Land at Gosford

Technical Note 11: Response to Oxfordshire County Council (OCC)

22nd June 2023

Context Plan
1:1250

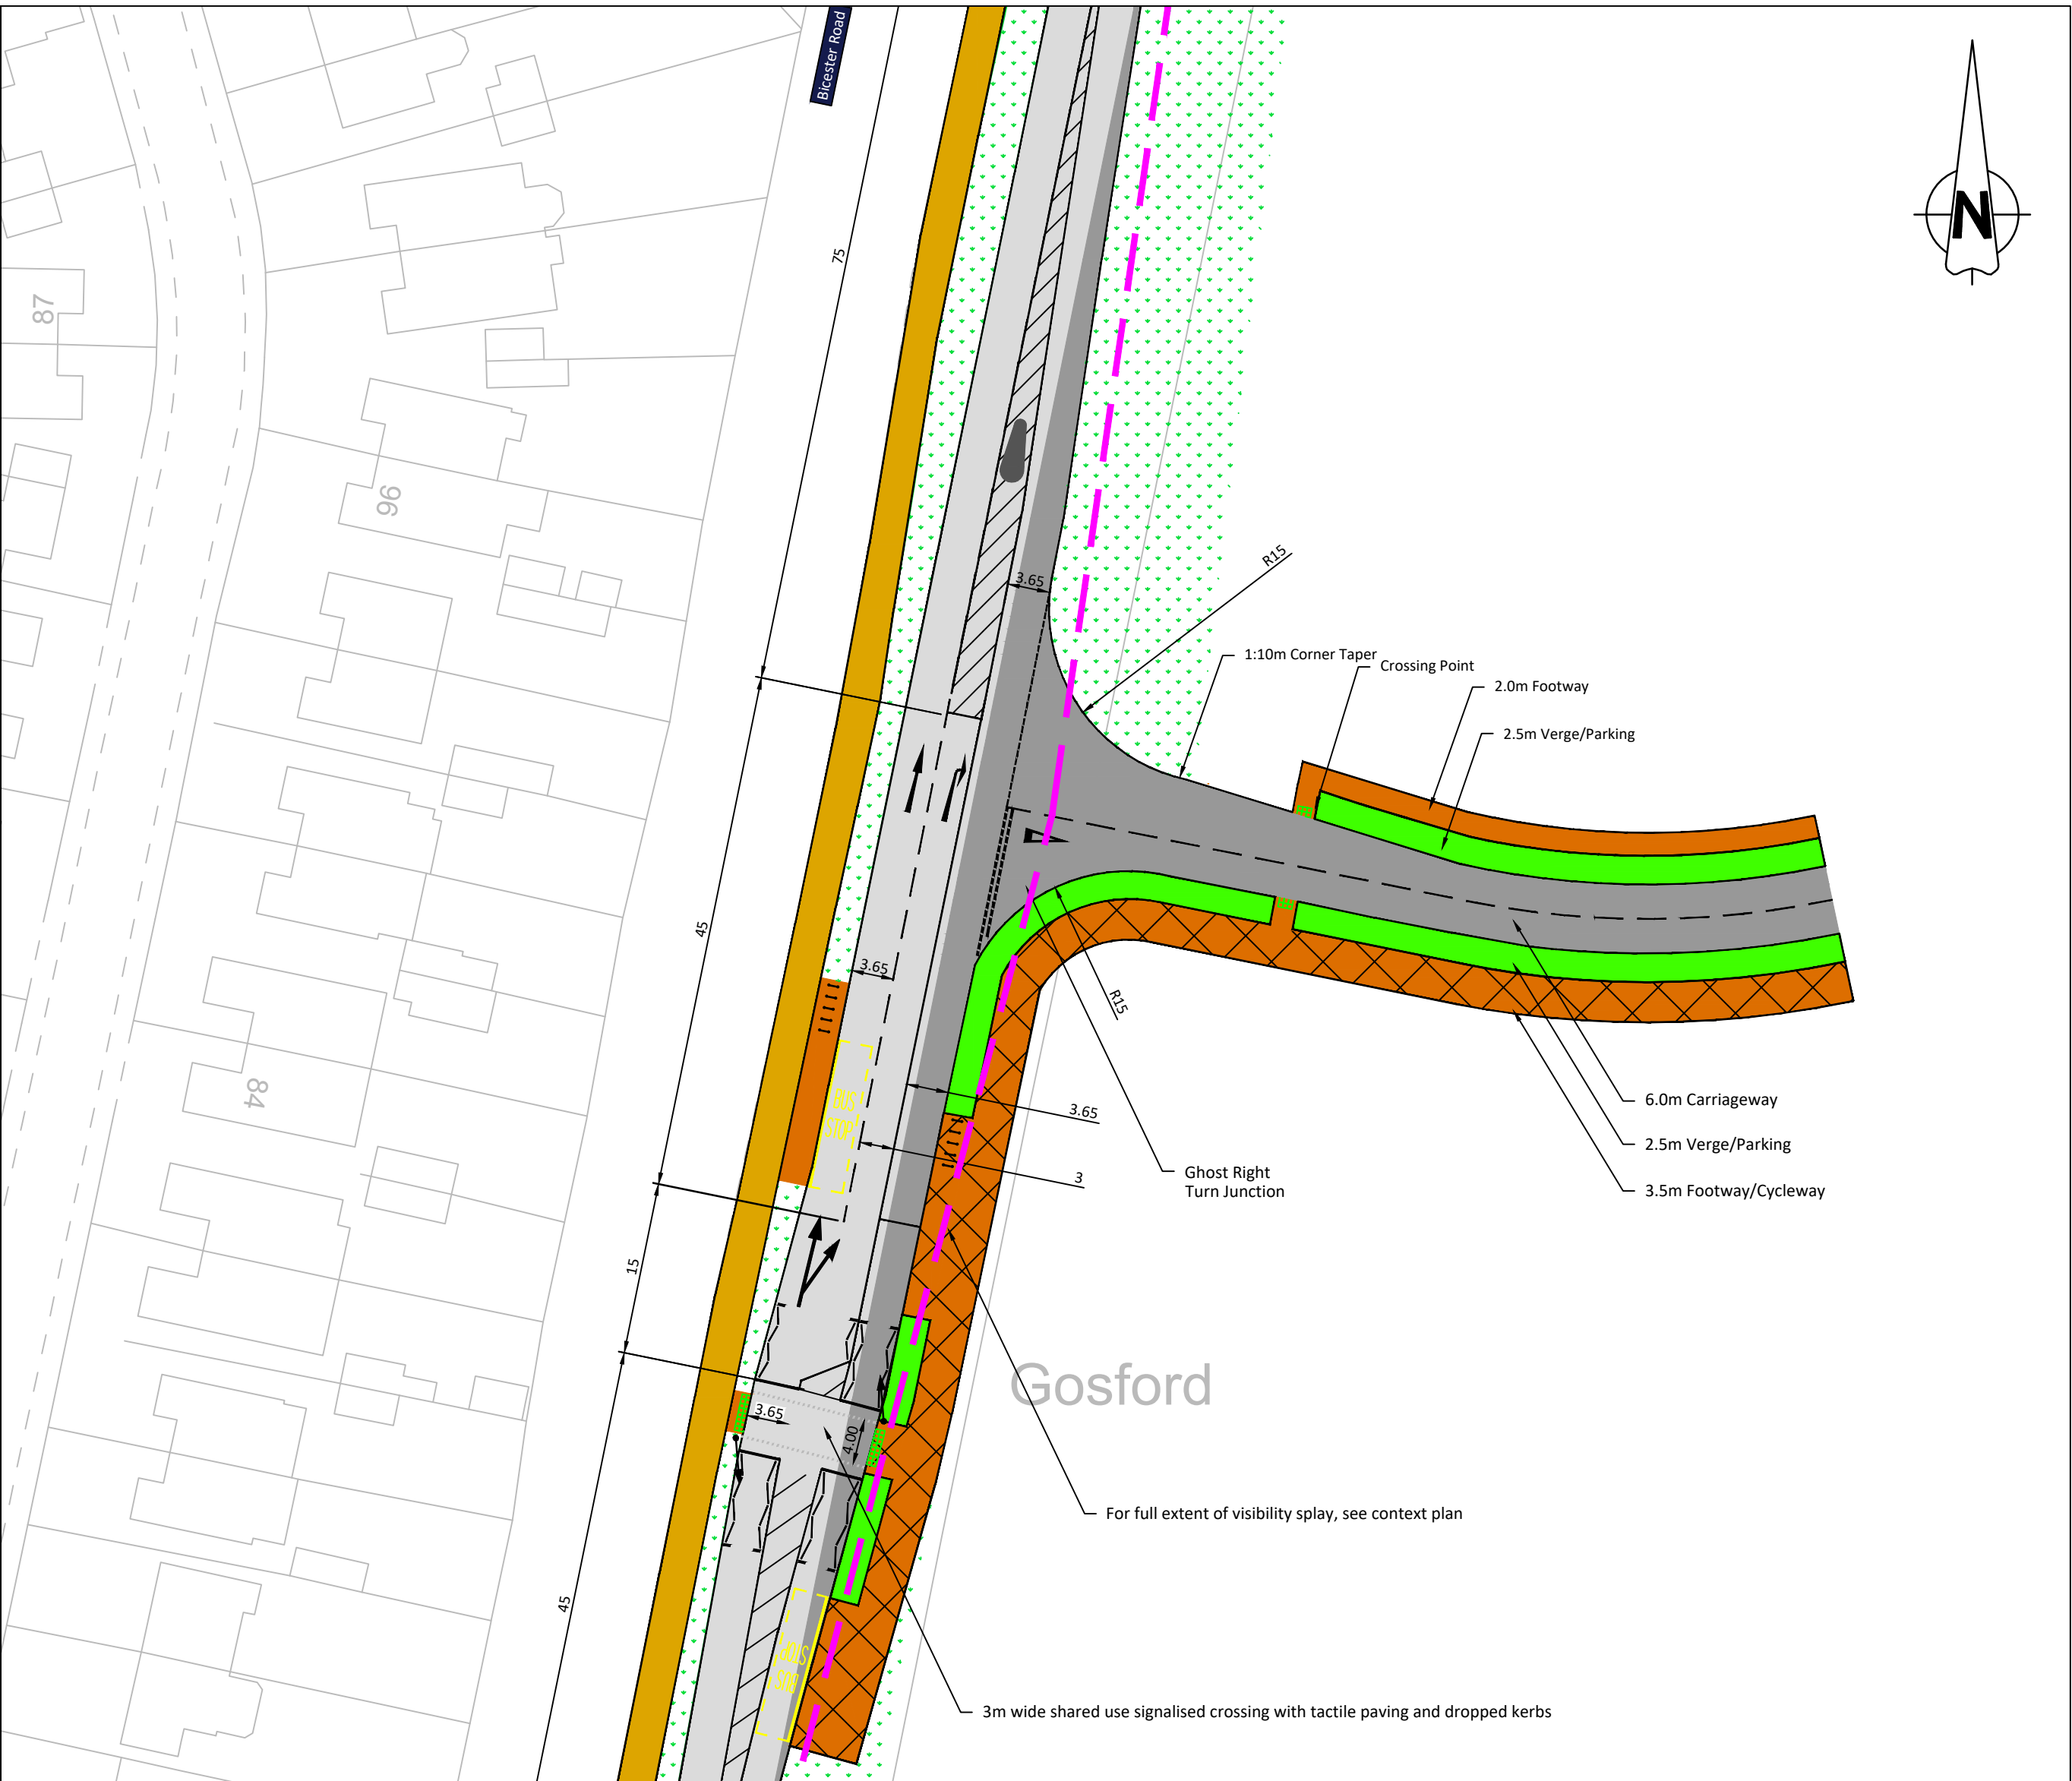
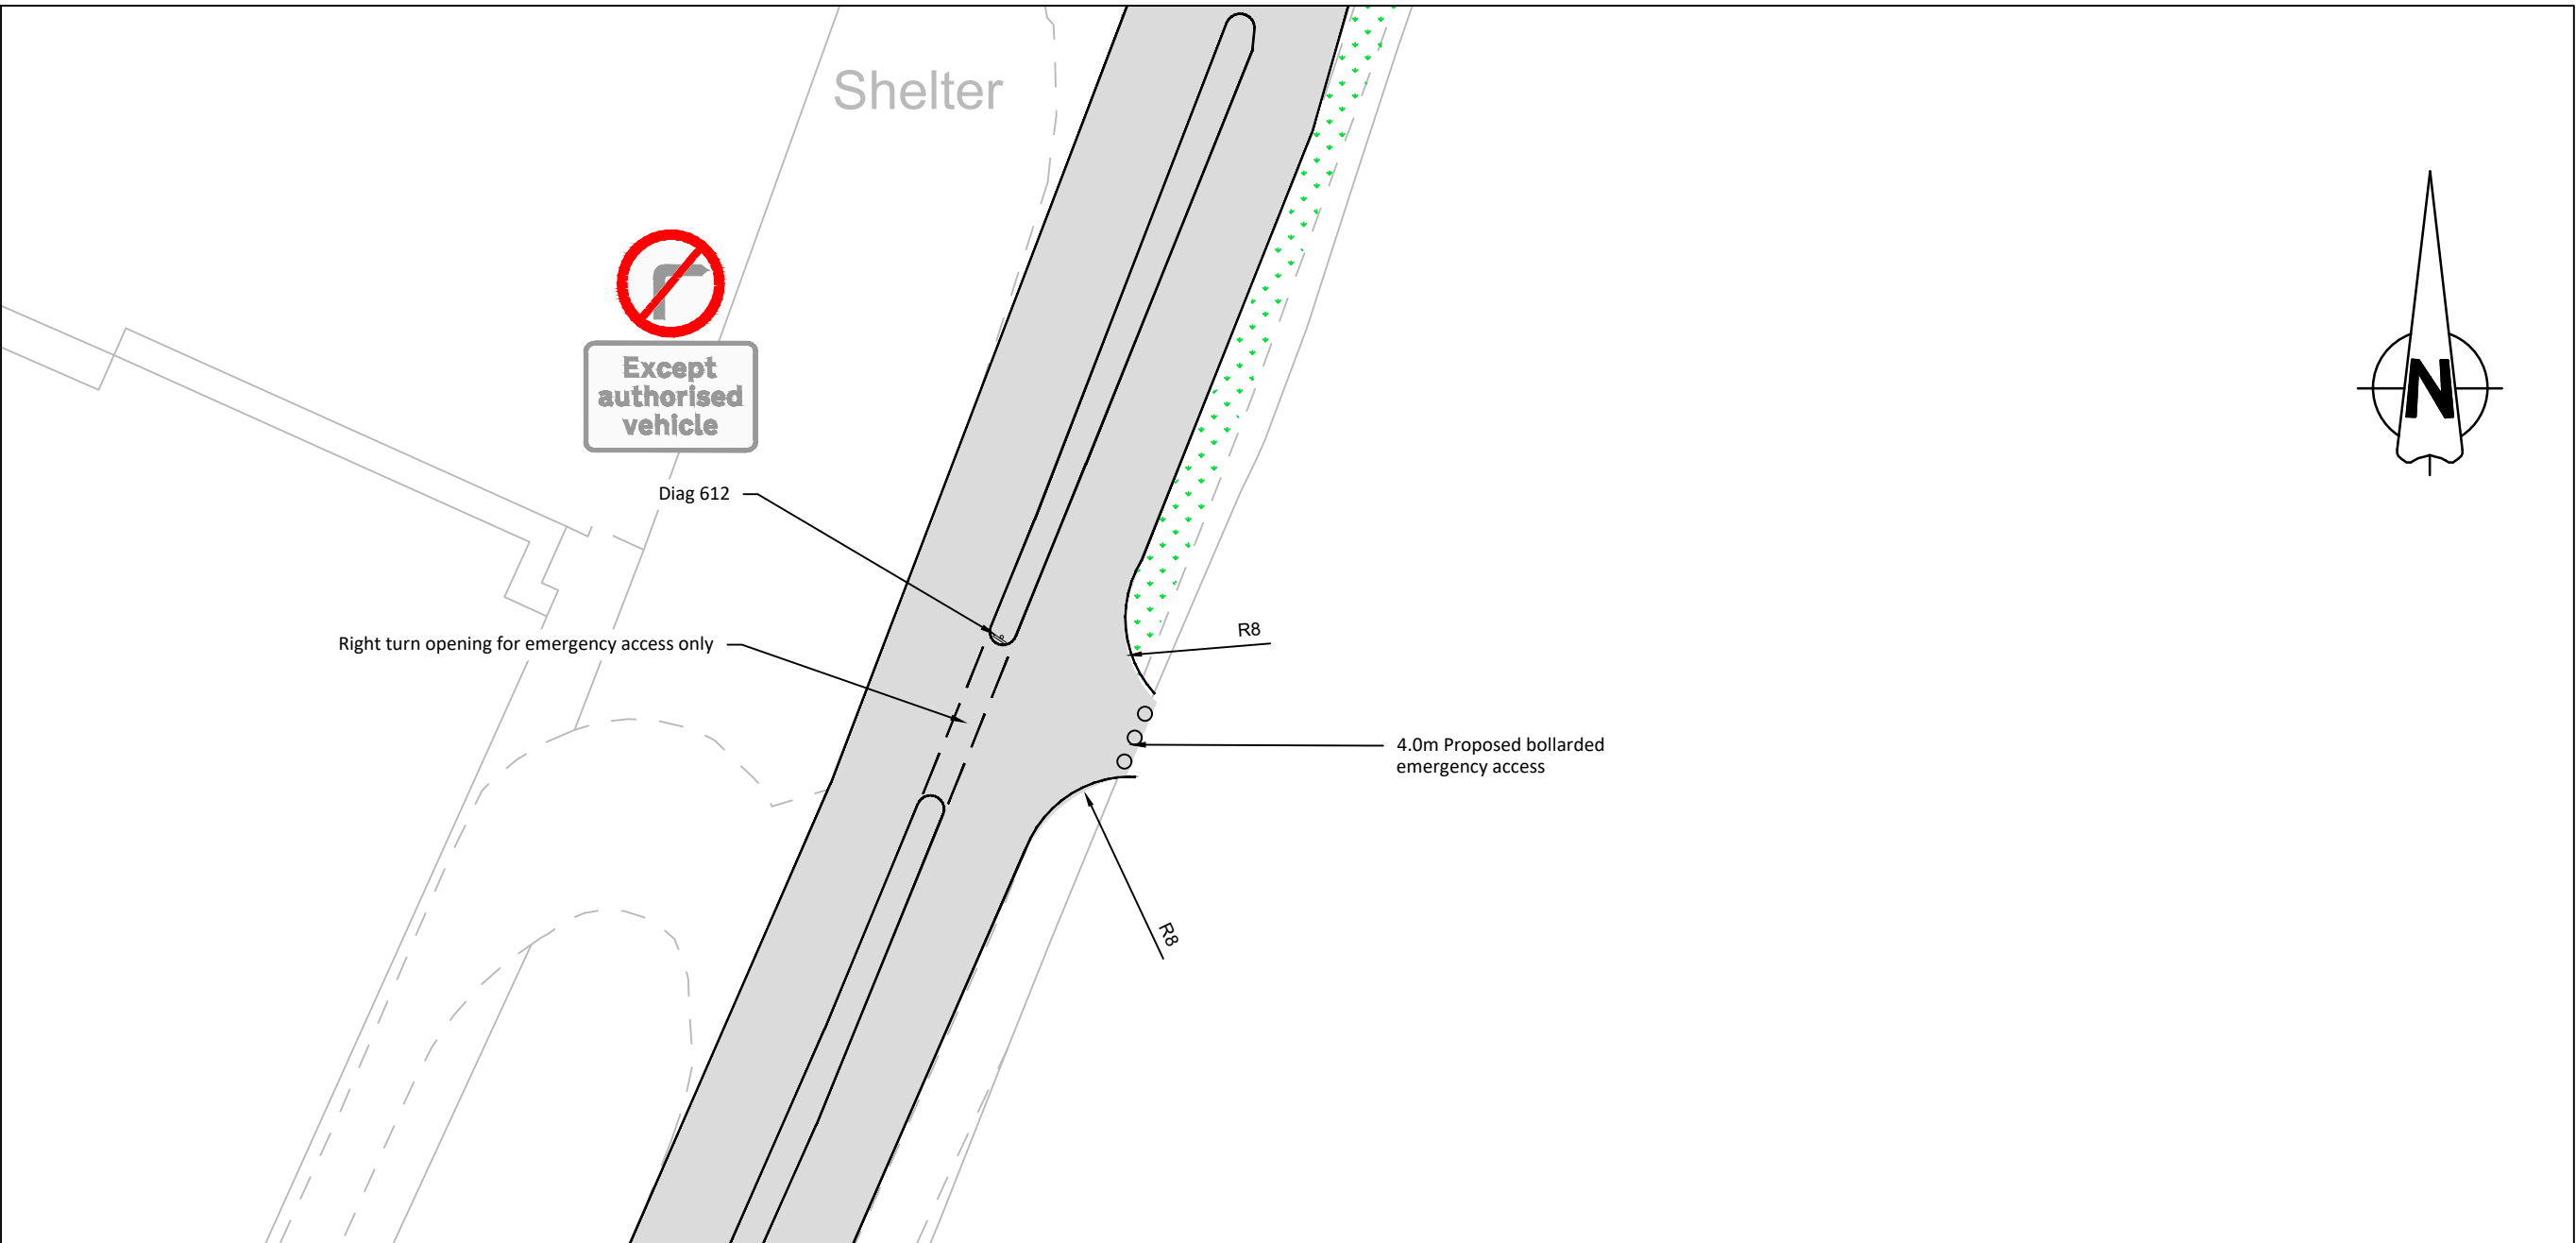
OCC Comment: Vehicular Access – Bicester Road runs along the western frontage of the site and so, several accesses shall be taken off it. The principal vehicular access for the entire PR7a allocation is proposed via a T junction ghost right turn off Bicester Road as shown by Drawing no. 10669-SK-05 Rev A. The vicinity of the site access along Bicester Road is fairly straight. The proposed access thereby benefits from adequate visibility splays although the splays need to be indicated on the access plan. Although not part of this submission, a second point of access into the parcel of land controlled by Hill shall be taken from a simple T junction off Bicester Road north of the cemetery which shall be delivered via a second planning application.

OCC Comment: The application proposes a number of pedestrian and cyclist access points to adjoining lands – this is welcomed. Along Bicester Road frontage, the application suggests up to two access points – via the principal site access and also utilising the downscaled existing site access. Both of these access

points are presenting unacceptable forms of provision that fail to meet guidance stipulated by LTN1/20. These are:

1. *Uncontrolled crossing on a busy 40mph Bicester Road is not acceptable. Such a crossing does not meet guidance of The Design of Pedestrian Crossings LTN2/95*
2. *Where existing access is being downgraded to pedestrian, the kerb line must be reinstated and instead dropped kerb type of access provided.*
3. *The type and design of crossing shown in the snippet below is unacceptable. It is not clear why the crossing has been staggered here. A suitable crossing that meets the needs of users and commensurate to the road speeds must be provided at this point.*
4. *We would suggest it is realigned to be straight.*

- 3.4** This is noted and the drawings has been amended to include the appropriate visibility splays. The revised drawing is contained in **Appendix B**.

- 3.7** Paragraph 10.4.5 of LTN 1/20 refers to Table 10-2, which suggests the type of crossing that is appropriate and continues to confirm that it is a guide only, and individual locations should be assessed on a case-by-case basis. It is important to note that the development will deliver a network of walking / cycling routes and does not rely on any single crossing point. The most dominant desire line is towards the south, trips in this direction can be achieved via the sustainable link across Bicester Road, or alternatively pedestrians and cyclists can travel through the development to exit at the southern access point adjacent to the existing signalised crossing. However, taking on board the observations raised by OCC the uncontrolled crossing on Bicester Road is to be replaced with a signalised crossing point with the stagger removed. The revised crossing layout is included within the site access arrangements and is shown within **Appendix B**.
